Date 26 January 2022
Our Ref 21/02018/FLH

Town and Country Planning Act 1990 (As Amended)
24 Holmwood Road, Cheam, Sutton
Single Storey rear extension

TITLE:
Proposed Elevations

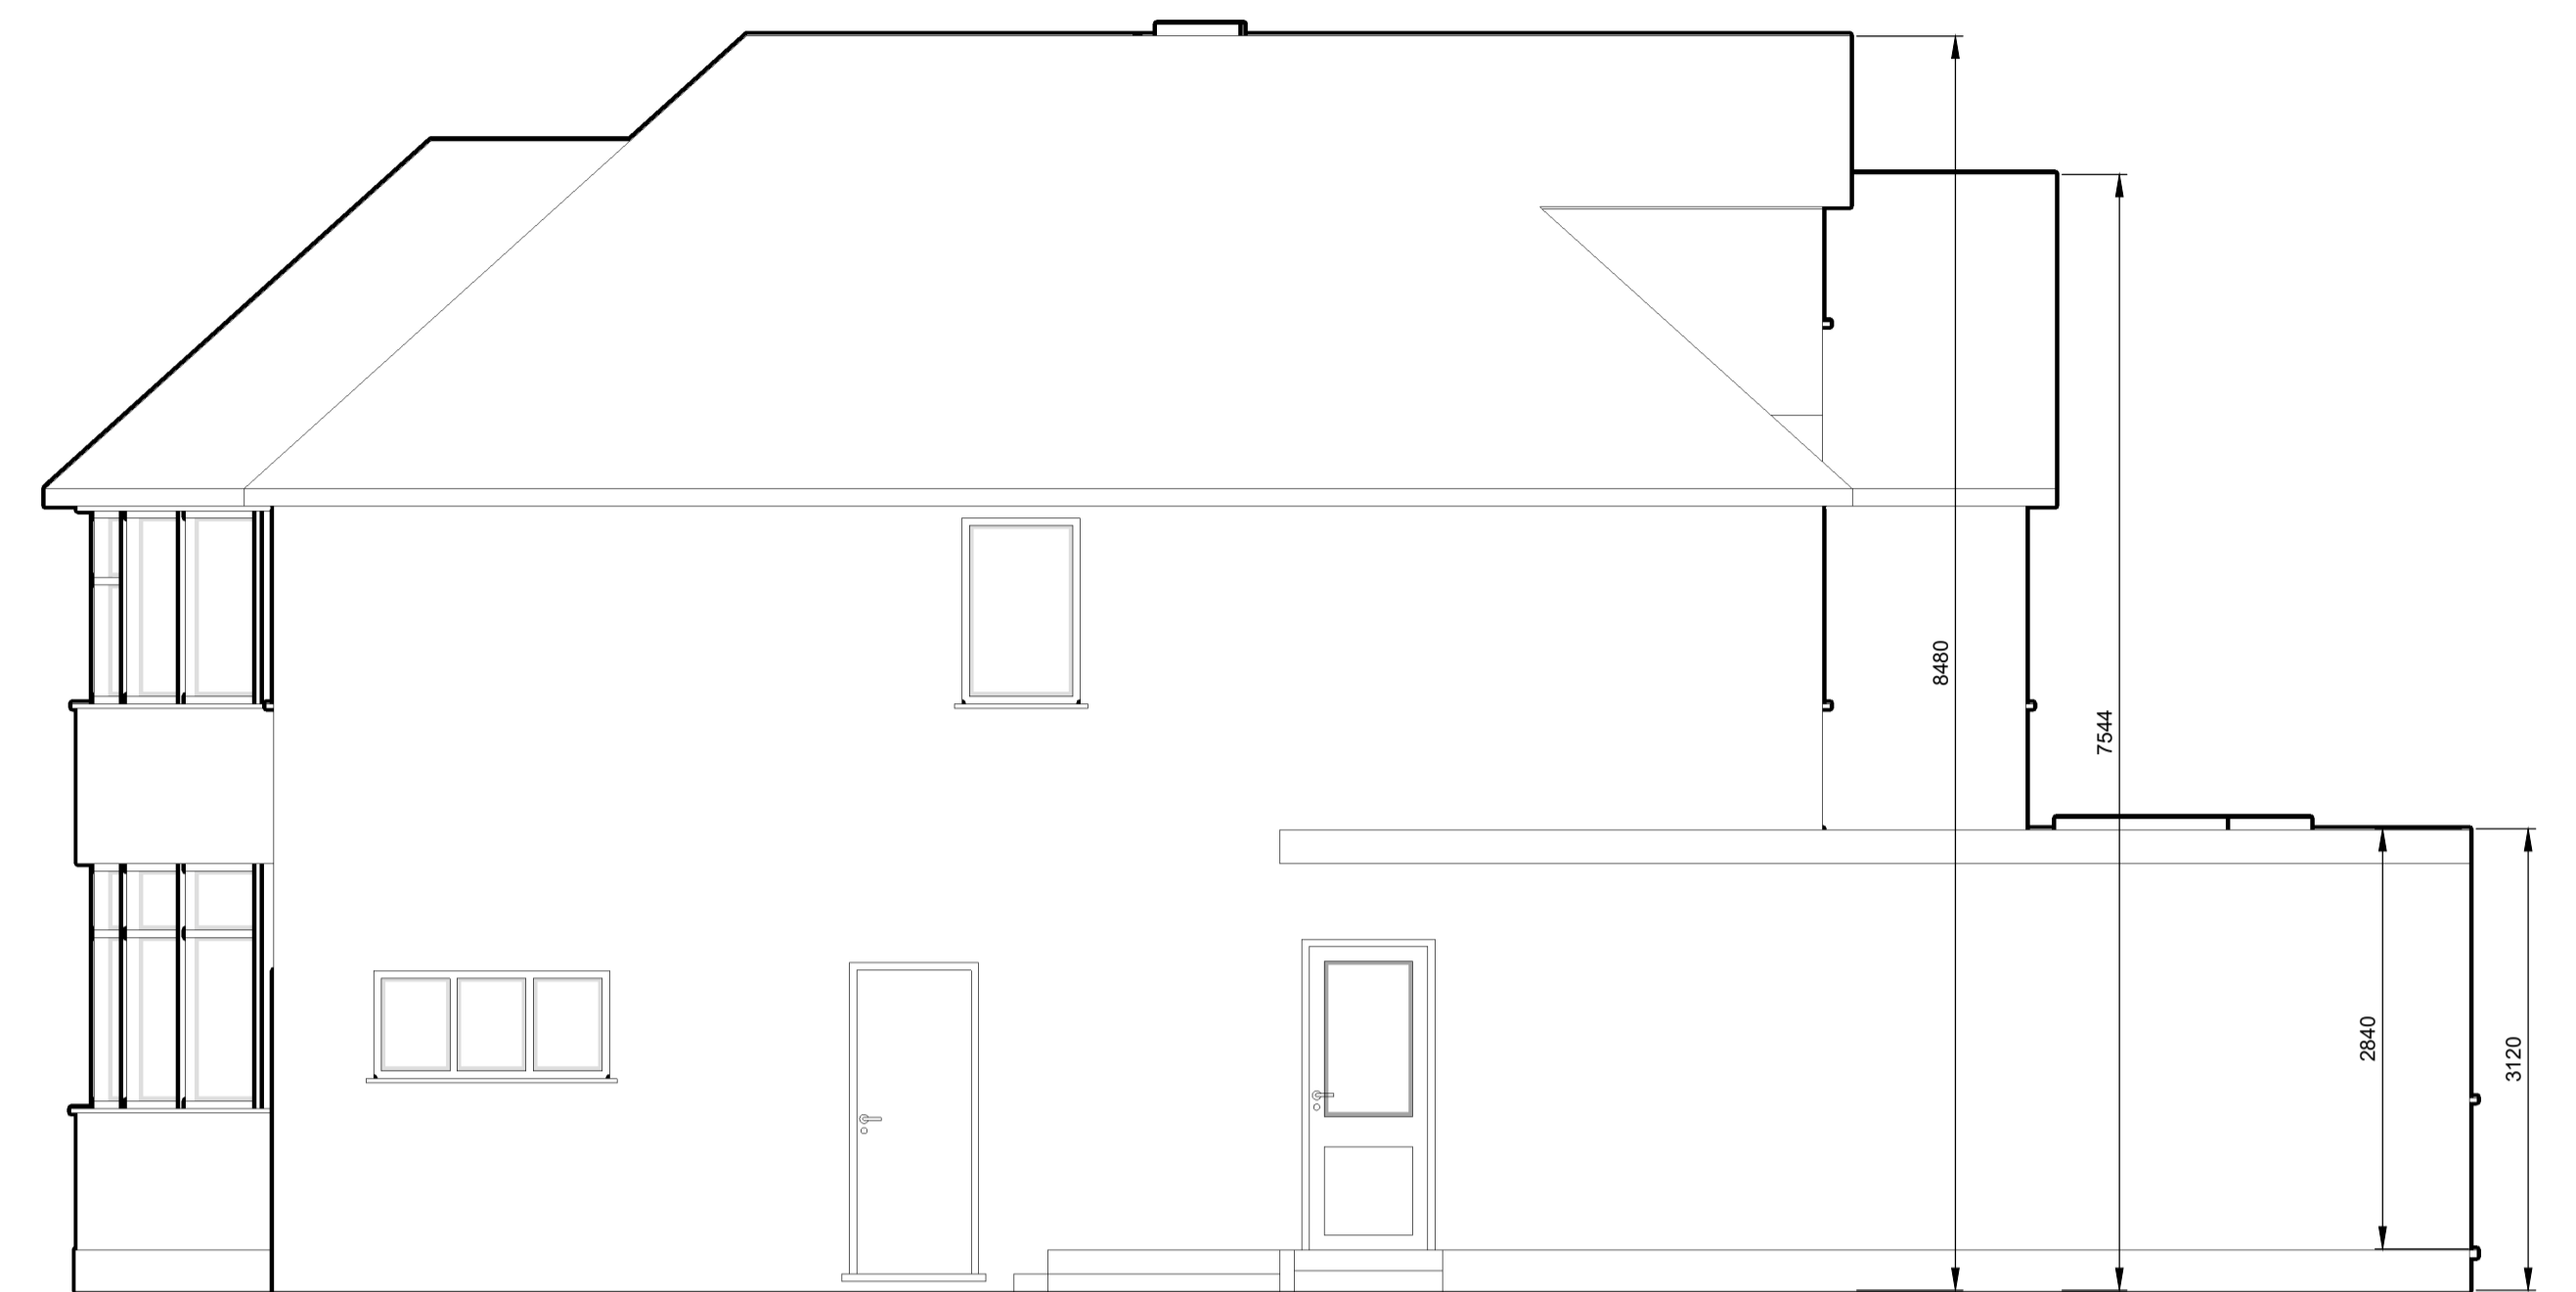
1 The applicant has stated in the submitted application that the proposal is for single storey rear extension, however, the submitted plans is showing rear extension as well as alteration and extension of roof involving conversion of loft space to habitable use. Please provide proposed plans relating only to the single storey rear extension.
